RE: Murphy Express – 1358 Wyoming Blvd
Grading Plan and Drainage Report
Stamp Date: 9/8/17
Hydrology File: J20D037

Based upon the information provided in your submittal received 9/14/17, the Grading Plan and Drainage Report **is not** approved for Building Permit. The following comments need to be addressed for approval of the above referenced project:

Figure 3.1. Engineering Design Drawing for Filtrex[®] Engineered Soil

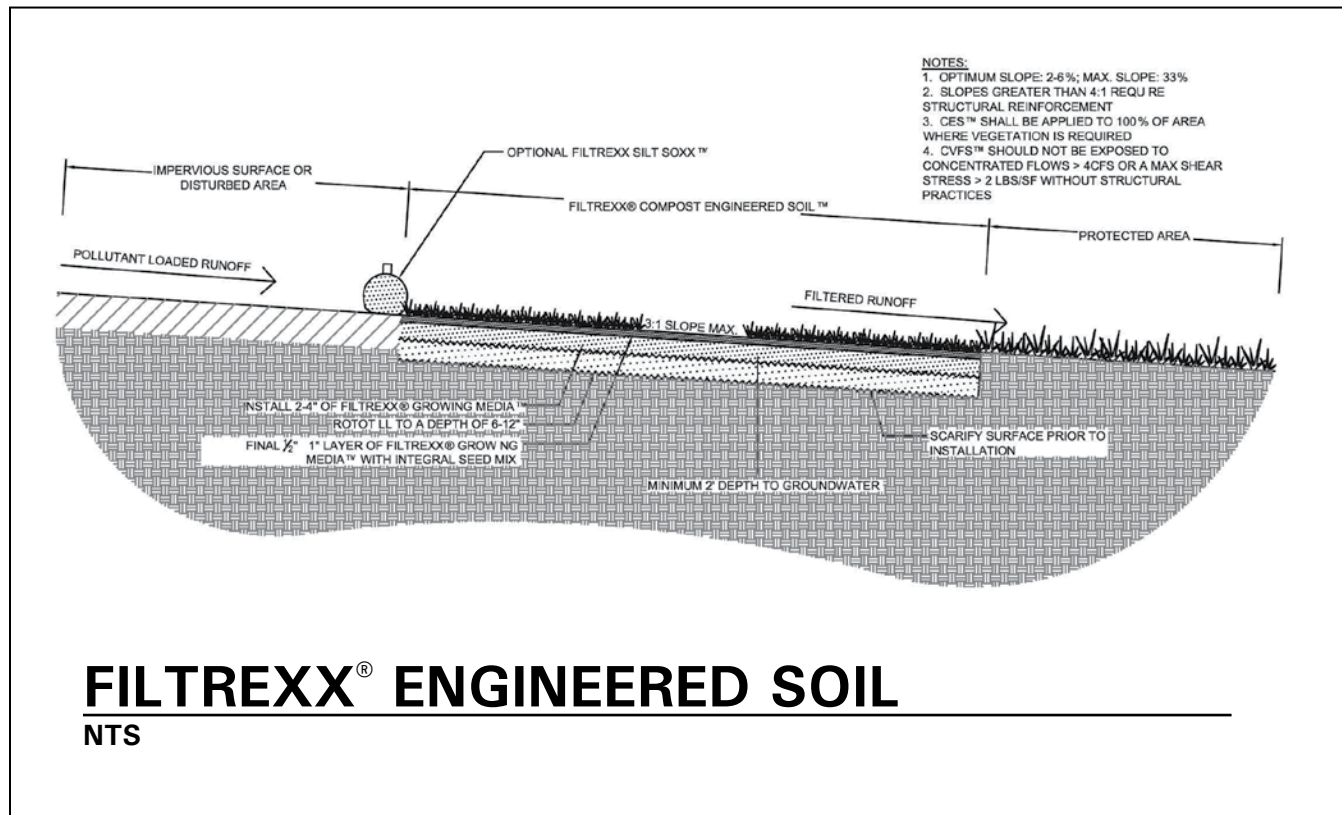
1. Appendix "A" – Bio Retention Area. Please look into your use of Filtrexx® within the water quality pond. Here in Albuquerque, unless this area is going to be irrigated, all water quality ponds are usually graveled. If you want to use landscaping please make sure it fits with xeriscape theme.
